CITY OF ALBUQUERQUE

September 25, 2017

Re: Yale Retail & Apartments
416 Yale Ave. SE
Traffic Circulation Layout
Architect's Stamp 9-19-17 (K16D011)

Based upon the information provided in your submittal received 9-20-17, the above referenced plan cannot be approved for Building Permit until the following comments are addressed:

TRAFFIC CIRCULATION LAYOUT APPROVED
[Signature]
 Signed _____ Date **10-25-17**

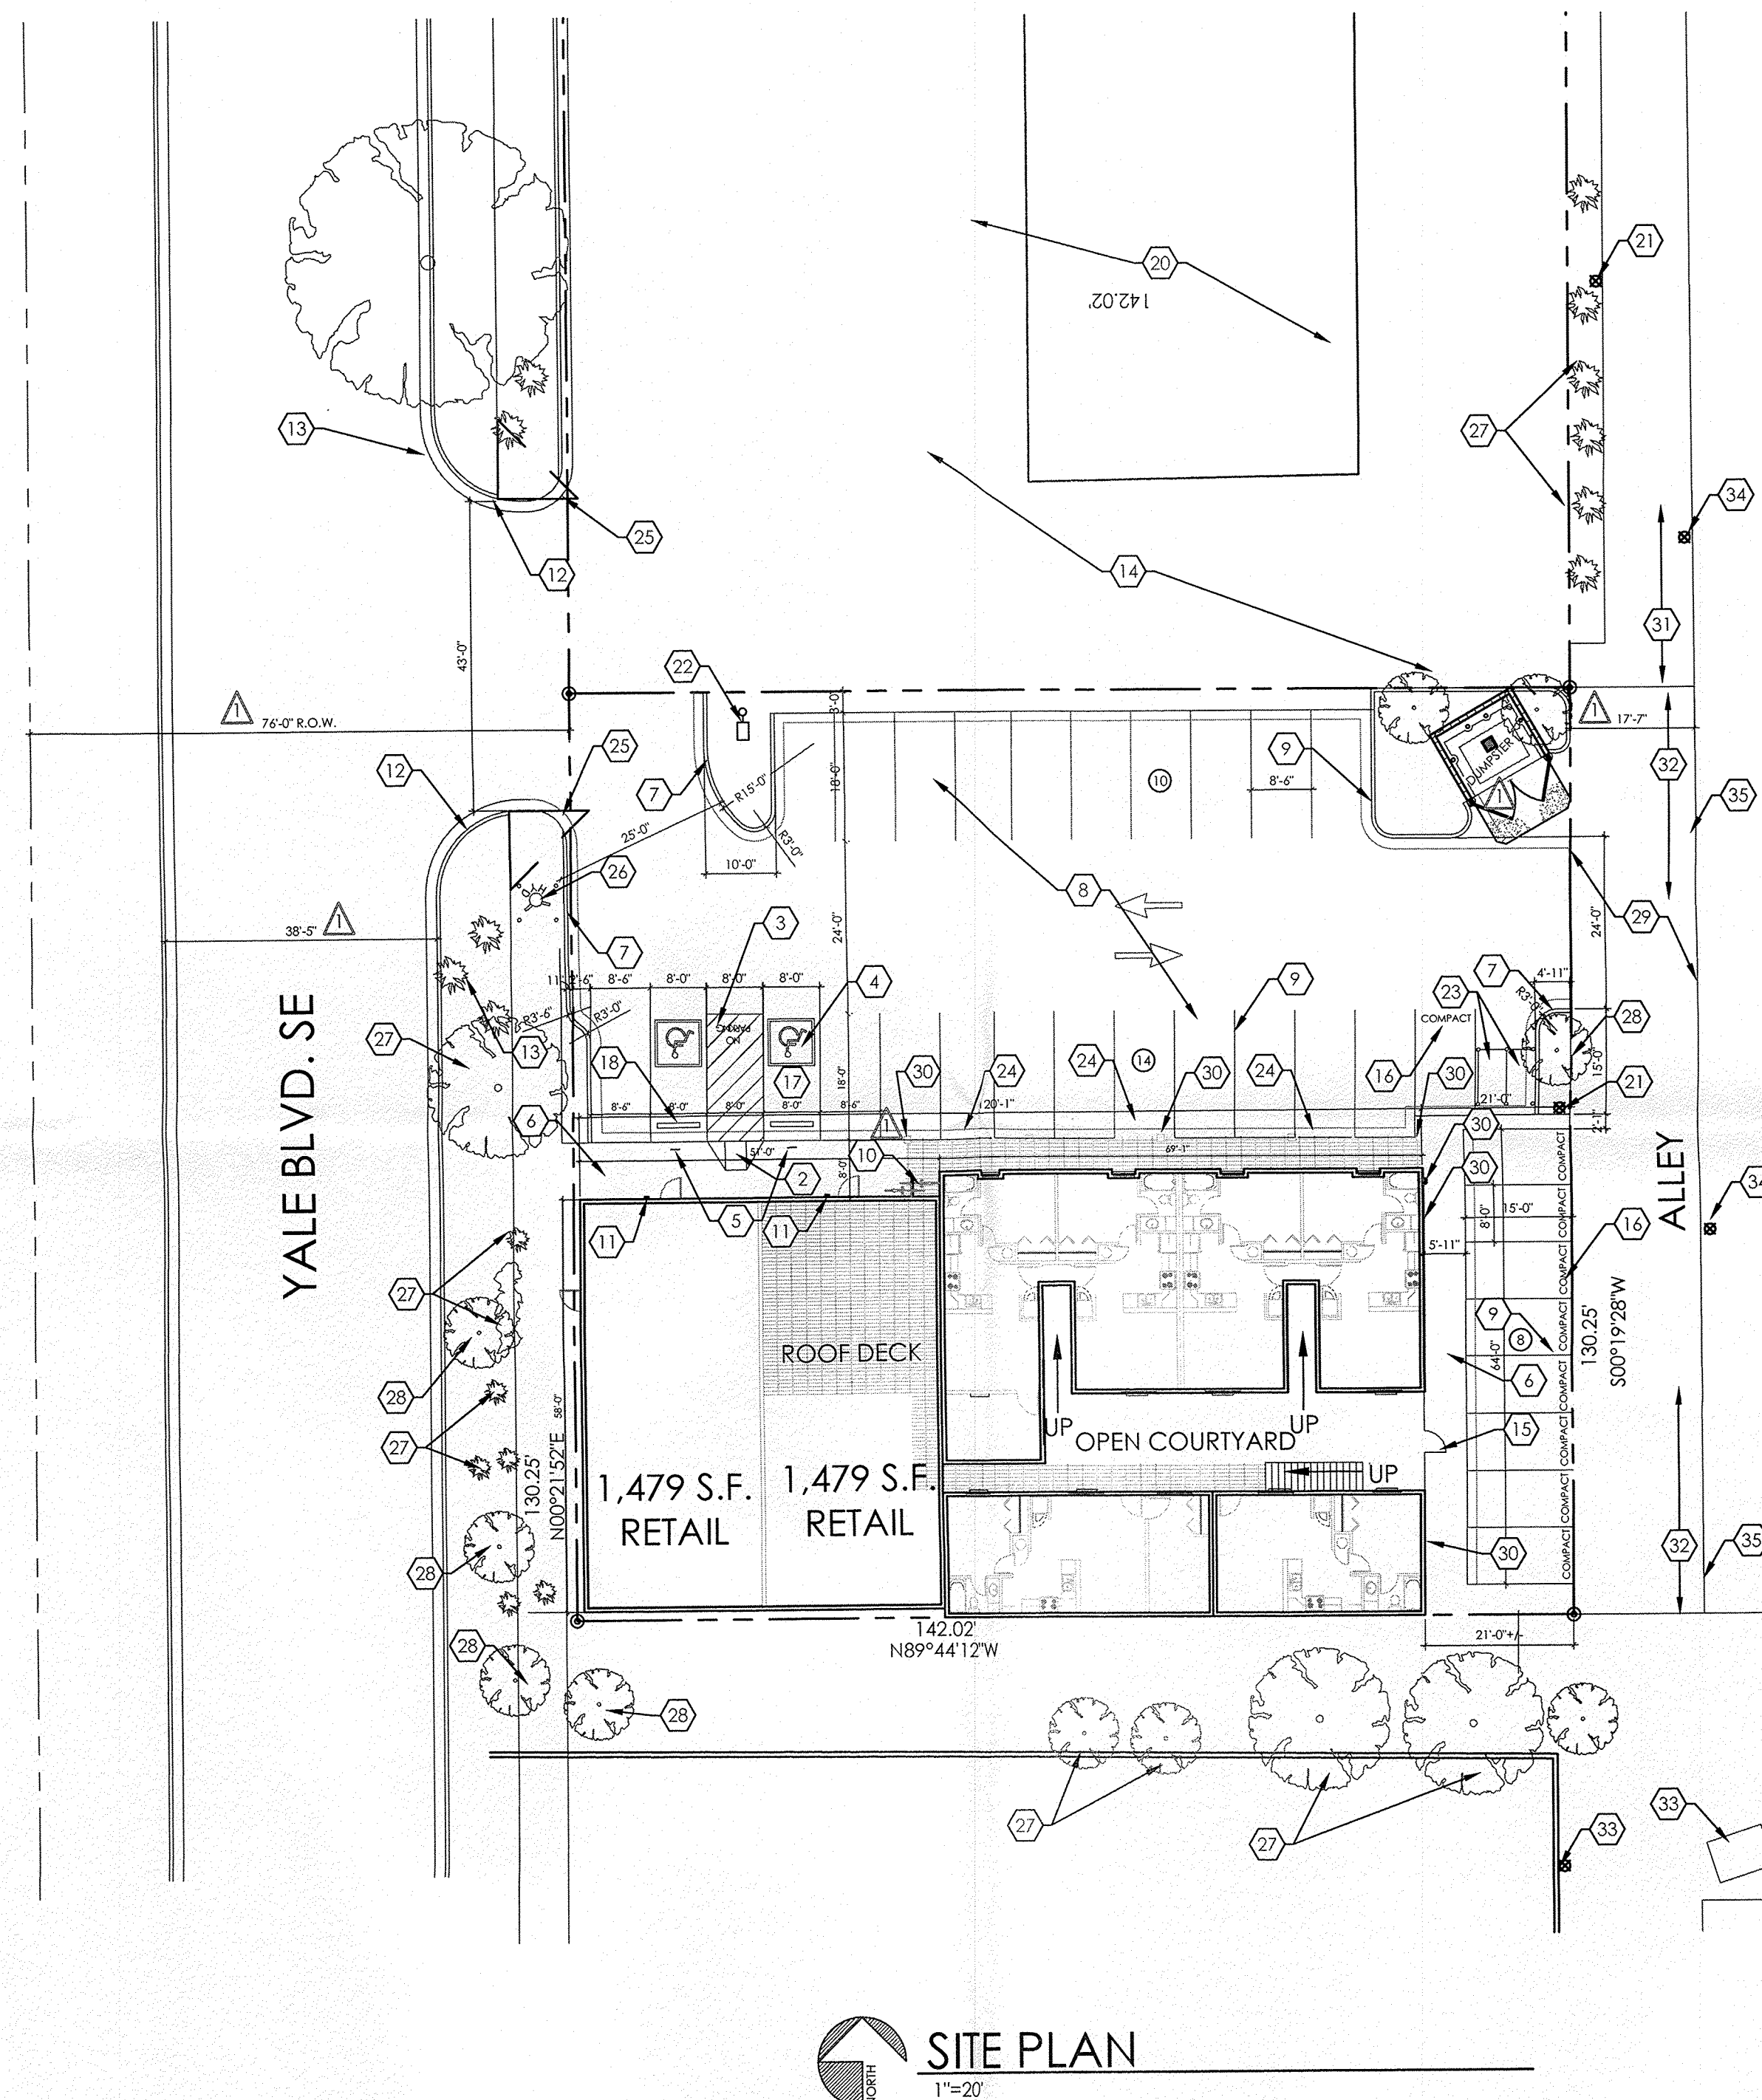
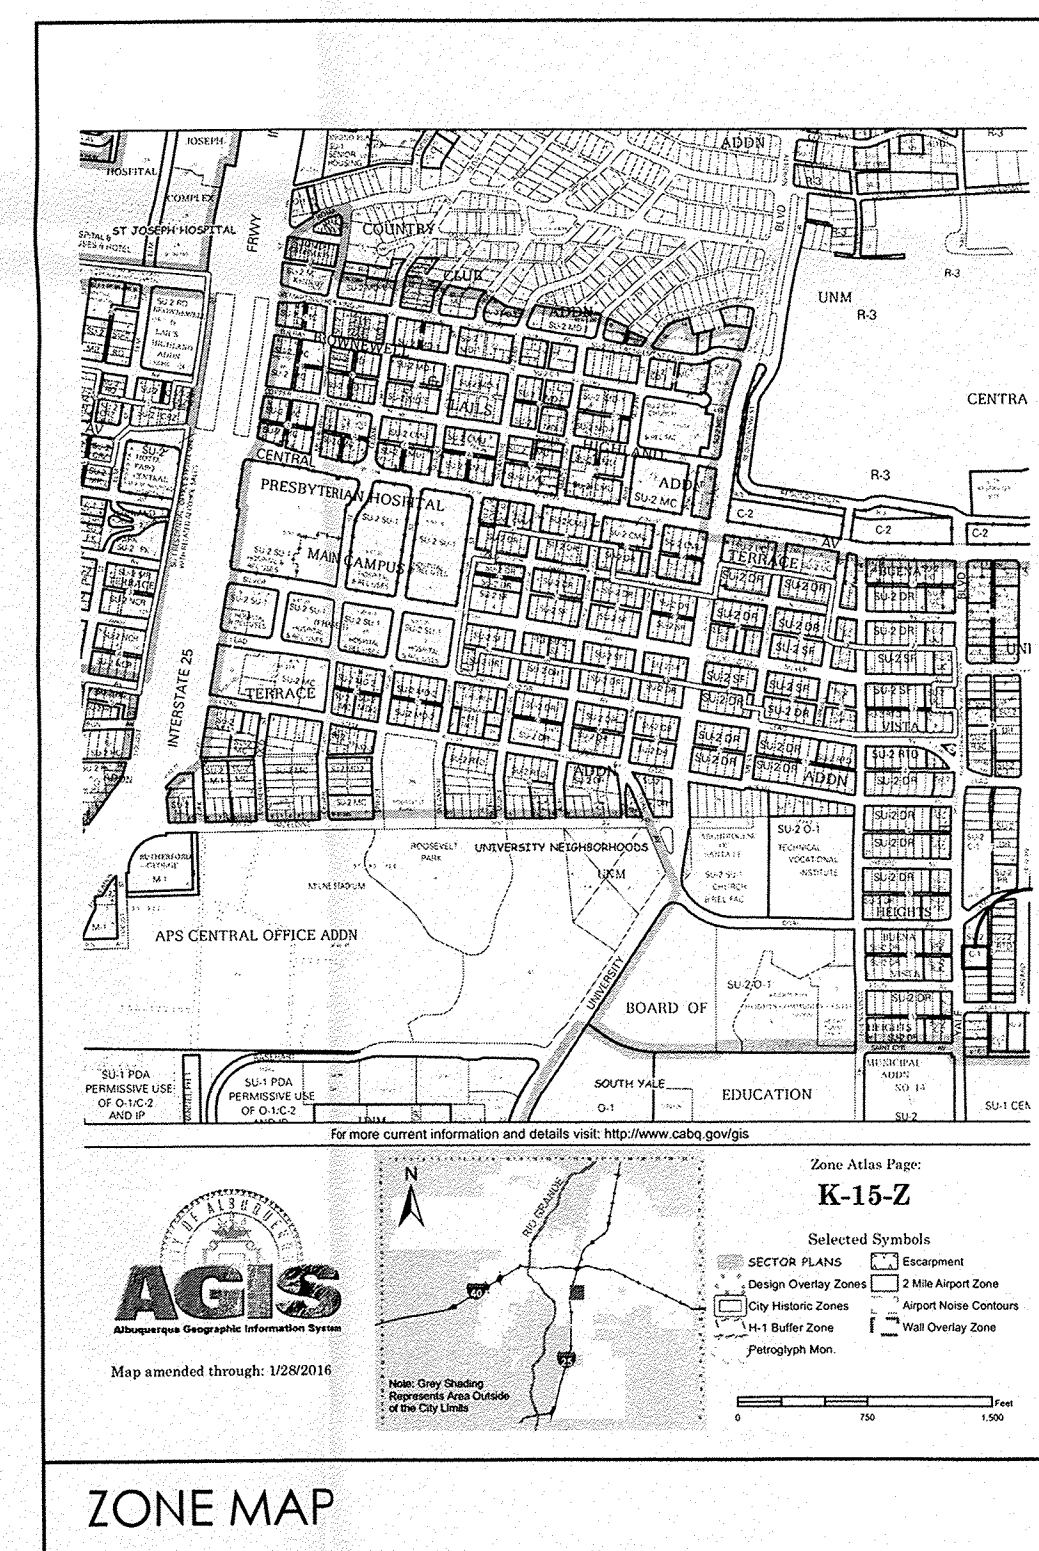
1. Identify the right of way width, medians, curb cuts, and street widths on Yale Ave. and on the Alley.
2. The Bicycle Rack and Dumpster Enclosure should be placed in the property.
3. Where the premise has a dumpster enclosure and/or four or more off-street parking spaces which require access off of an alley shall be paved to City specifications from the parking access drive to a street.
4. Work within the public right of way requires a work order with DRC approved plans.
5. Provide a min 6" or max 8" high concrete barrier curb or other acceptable barrier between landscaping and parking areas and/or drive aisles. Please call out detail and location of barrier curb.
6. Please include a copy of your shared access agreement with the adjacent property owner.
